From: Sue Howell
Sent: 22 May 2017 16:10
To: Planning.Responses
Cc: Andrew Wood
Subject: RE: Please find attached amendment on planning application Ref: FG/198/16/PL

Further comment from Greenspace

APPLICATION FG/198/16/PL

Site Address: 1 Sea Drive Ferring BN12 5HD

JOB: 1 SEA DRIVE, FERRING, WORTHING BN12 5HD
DWG: PROPOSED SITE PLAN

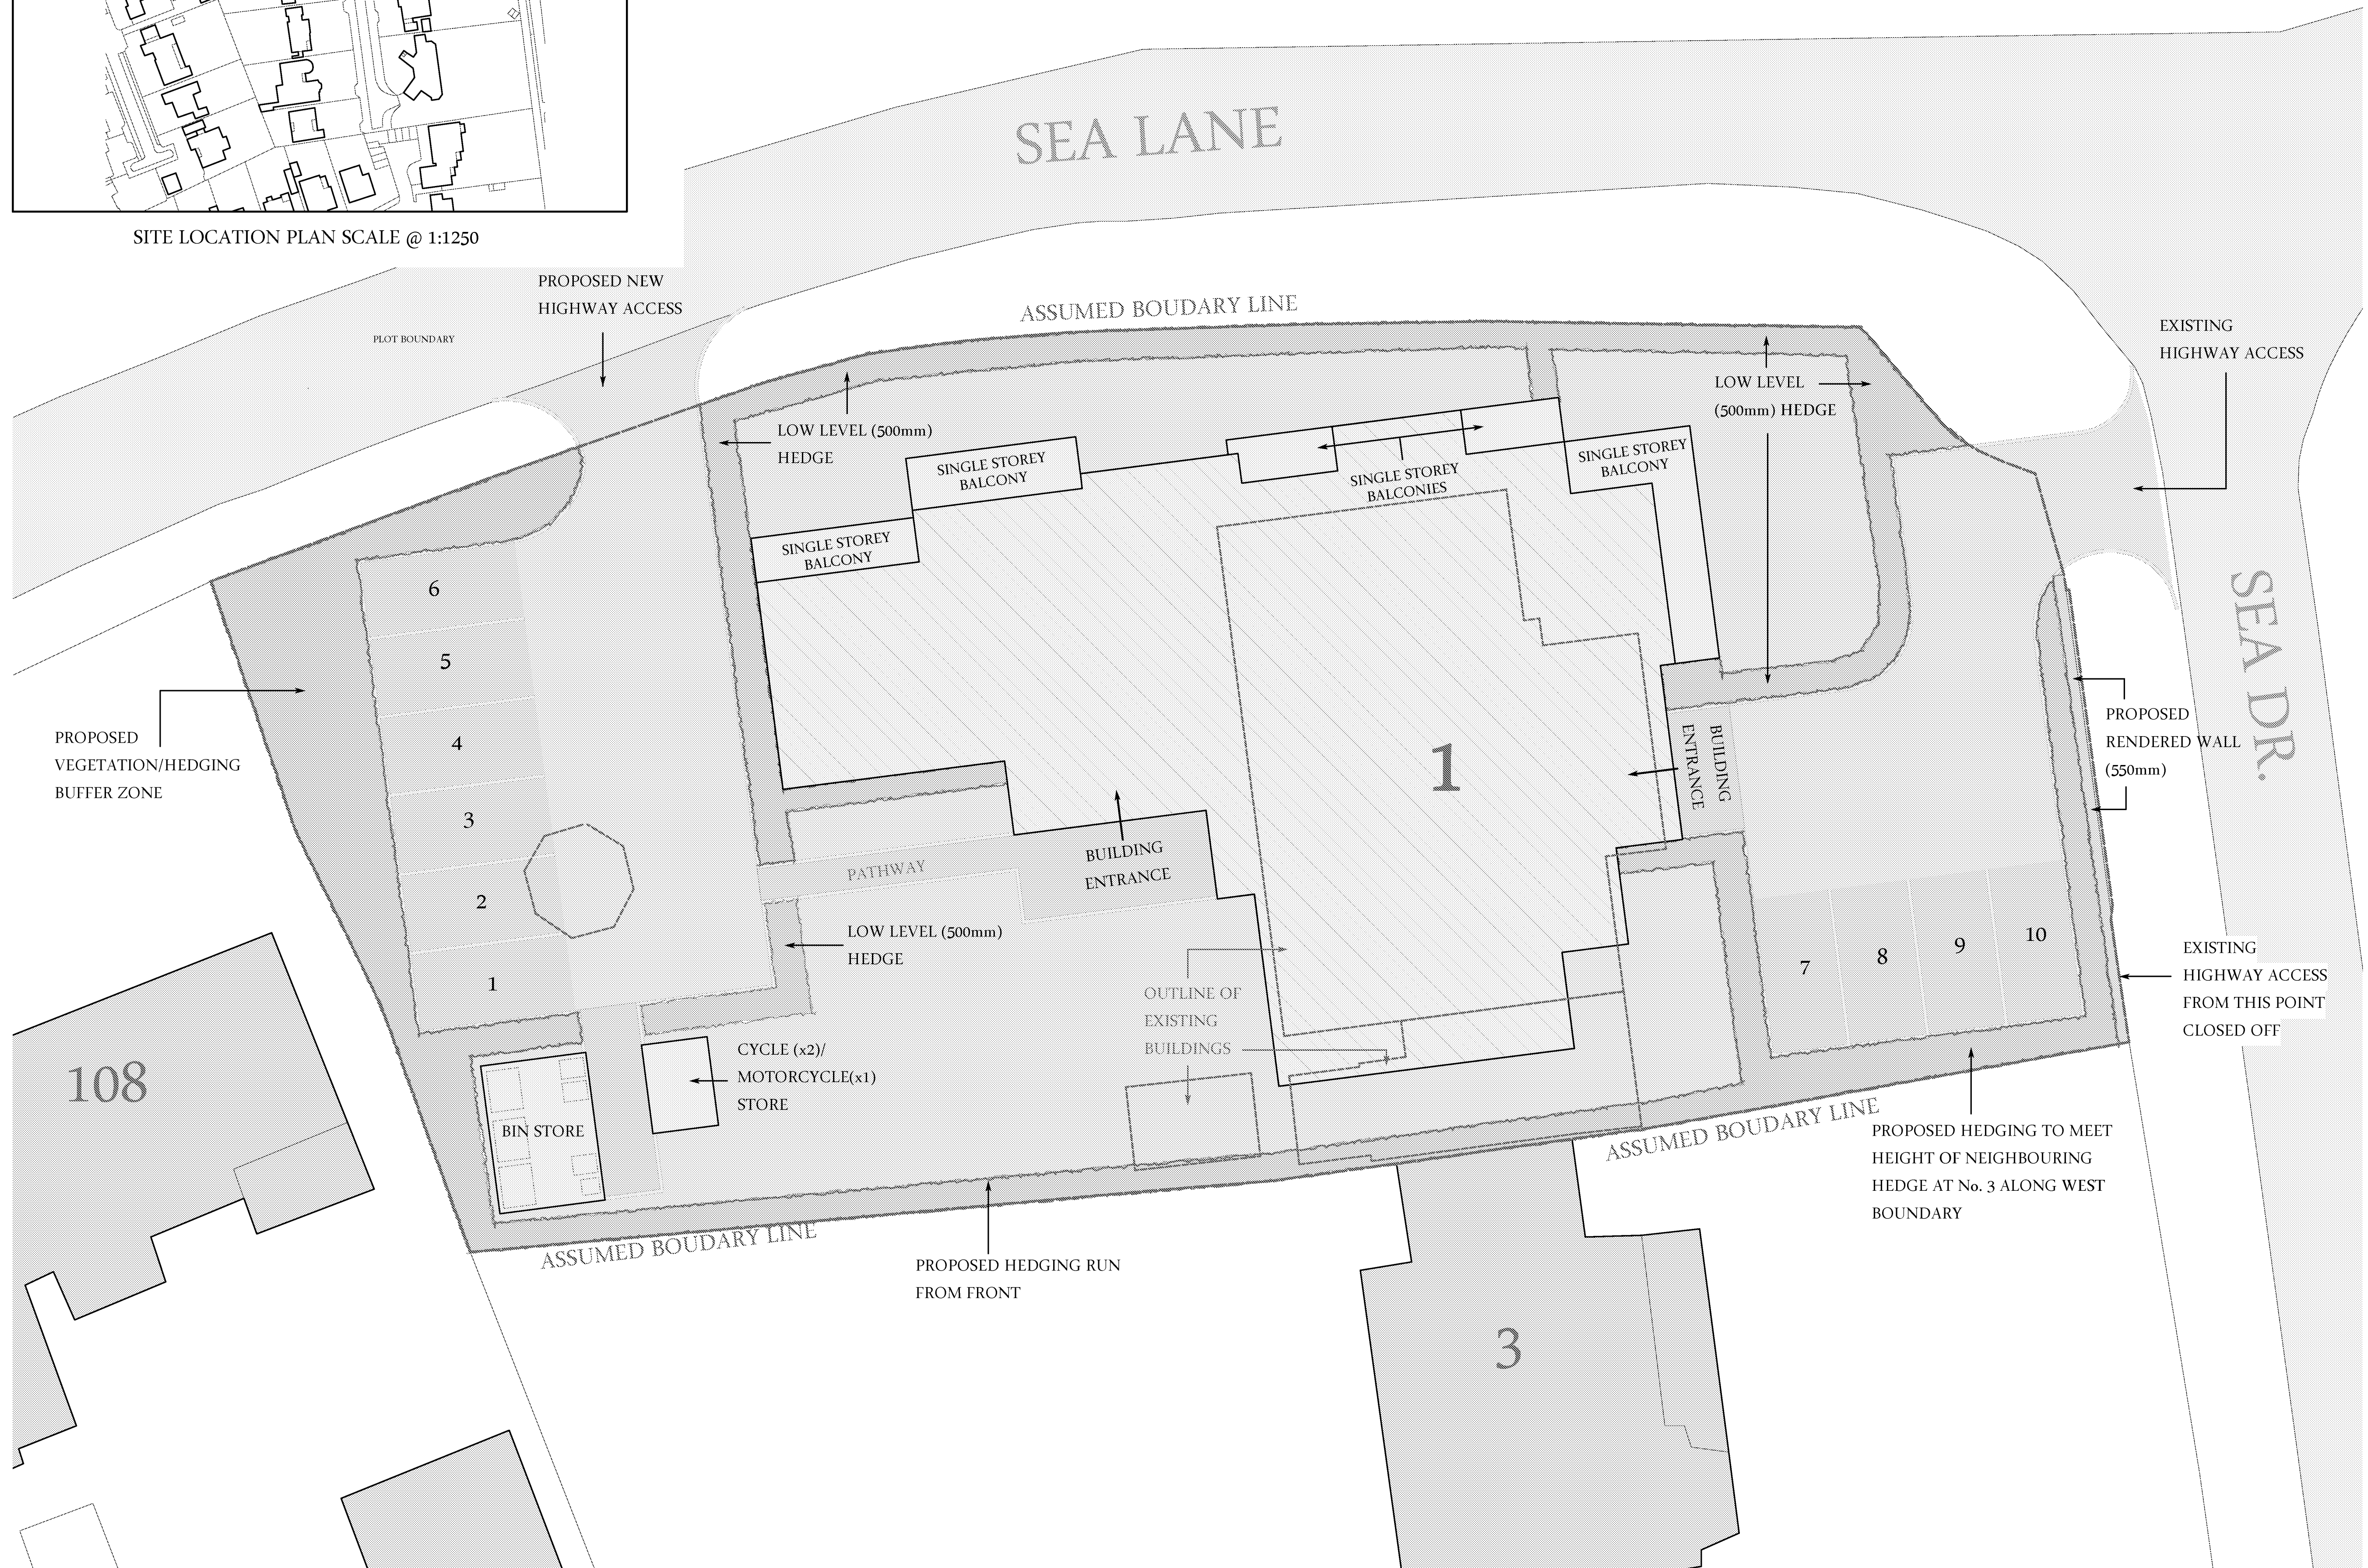
Further to submission of Dwg PL 002 Rev F we would request confirmation of proposals detailed as

- Proposed vegetation/buffer zone
- Proposed hedging run from front
- Low level hedge

Detail to be provided in plan form showing quantities proposed, species choice, planting density and size at time of planting. This is to ensure that the proposals are fitting for location and should be submitted for approval or at least conditioned as part of any decision.
